Subject: KittCo_ACU-24-00001_Horizon_Towers
U.S. 97 milepost 136.09 left

We have reviewed the proposed site plan and have the following comments.

TITLE
SITE PLAN

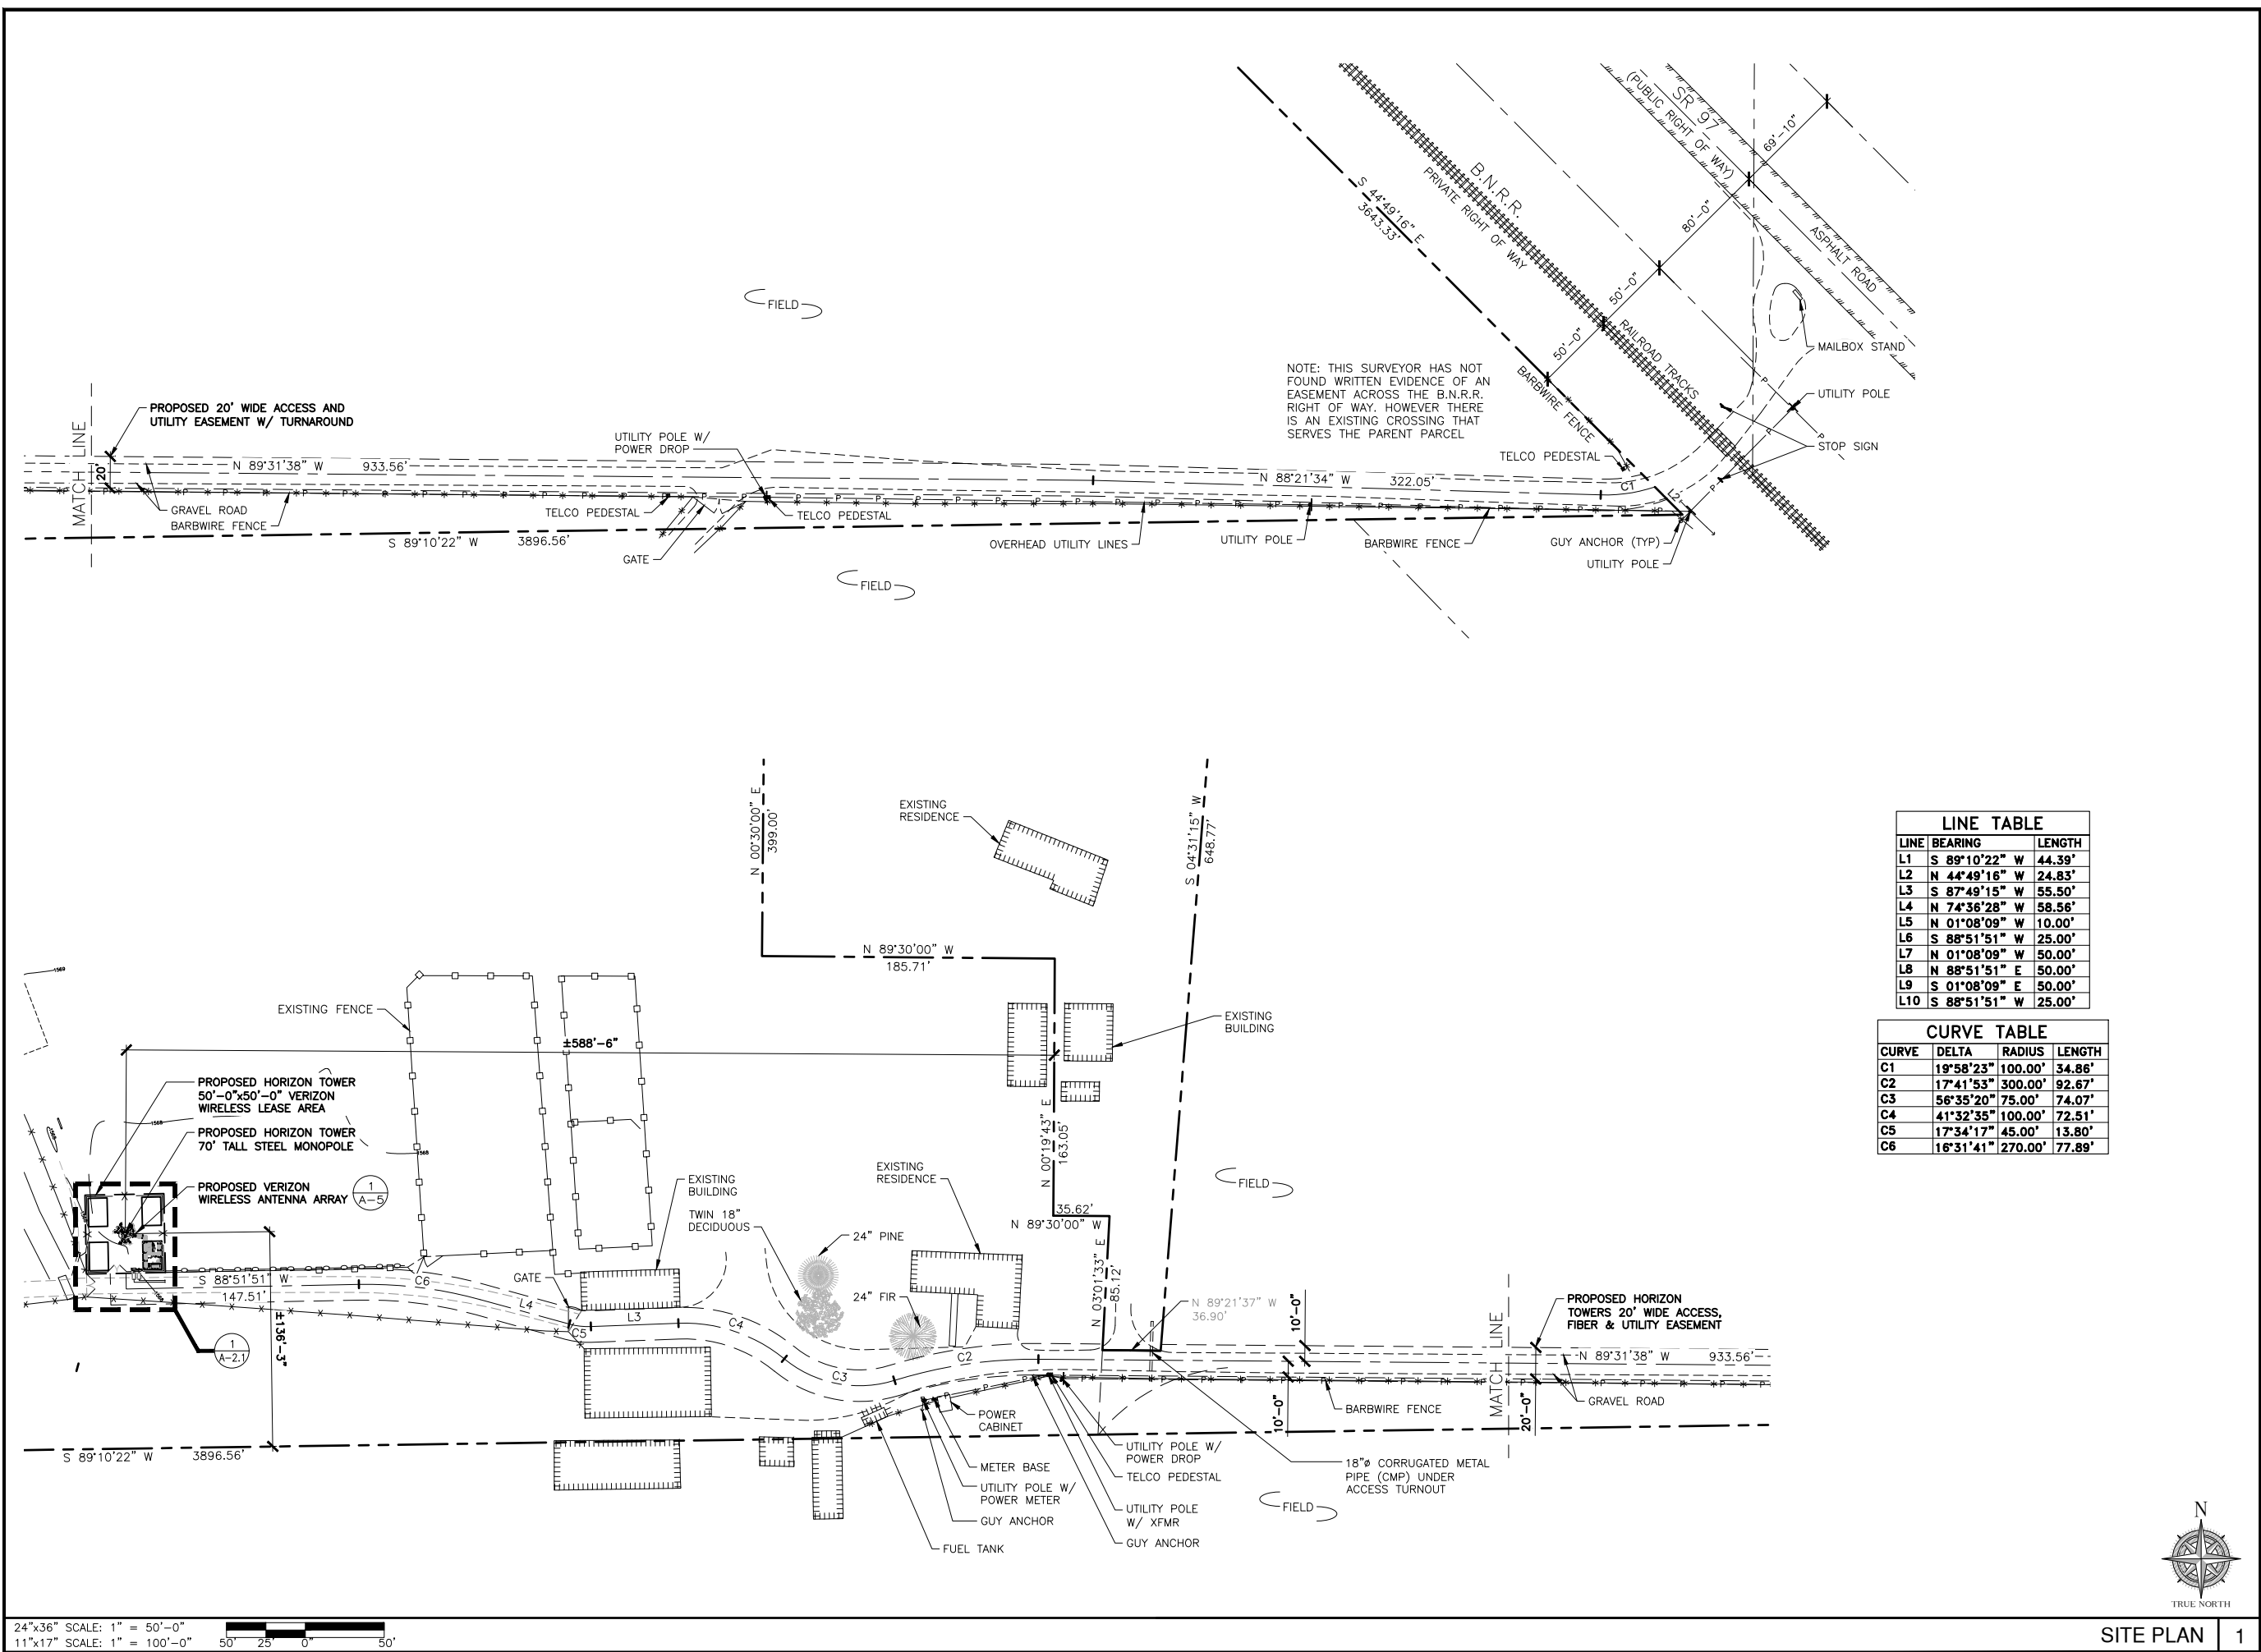
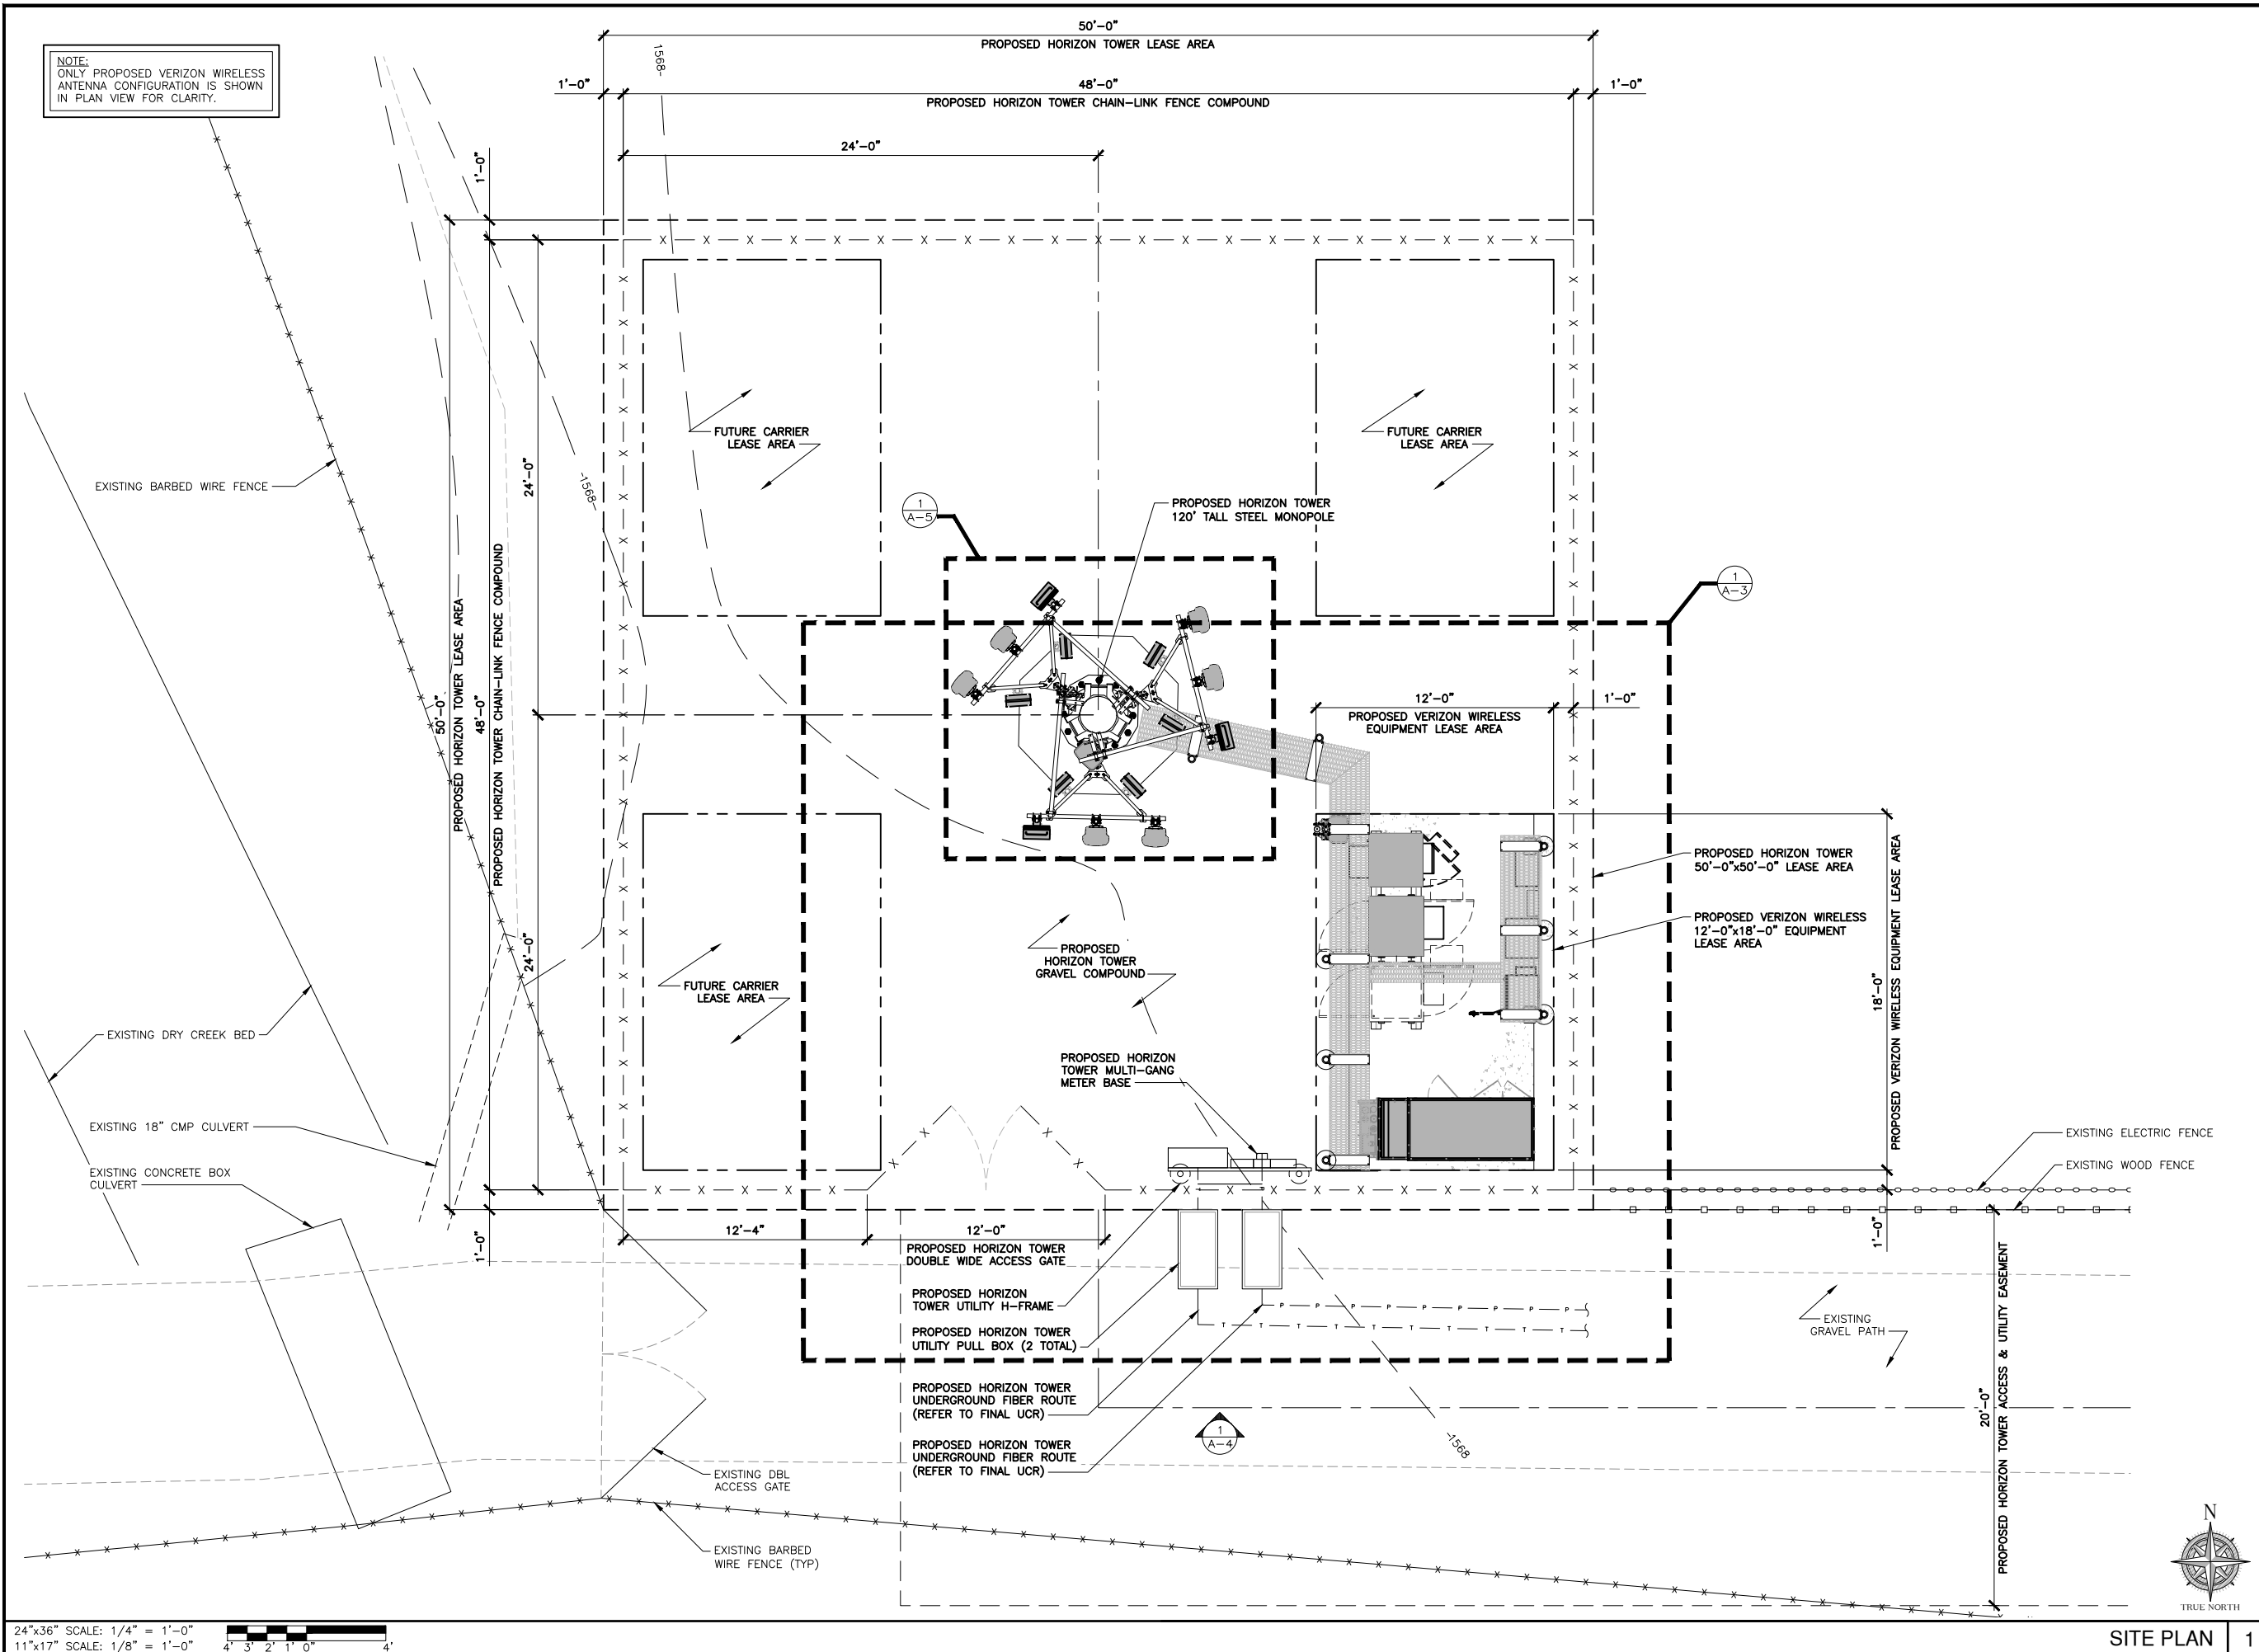
- The subject property is adjacent to U.S. Highway 97 (US 97), a Class 1 managed access highway with a posted speed limit of 55 miles per hour. Currently, access to the property is via the permitted joint use approach at milepost 136.09 left and a grandfathered approach at milepost 136.10 left. The permitted approach can be used but the permit must be updated. No additional approaches to US 97 will be allowed. The property owner is required to contact Mark Kaiser of the WSDOT - South Central Region Office at (509) 577-1668 to update the permit.
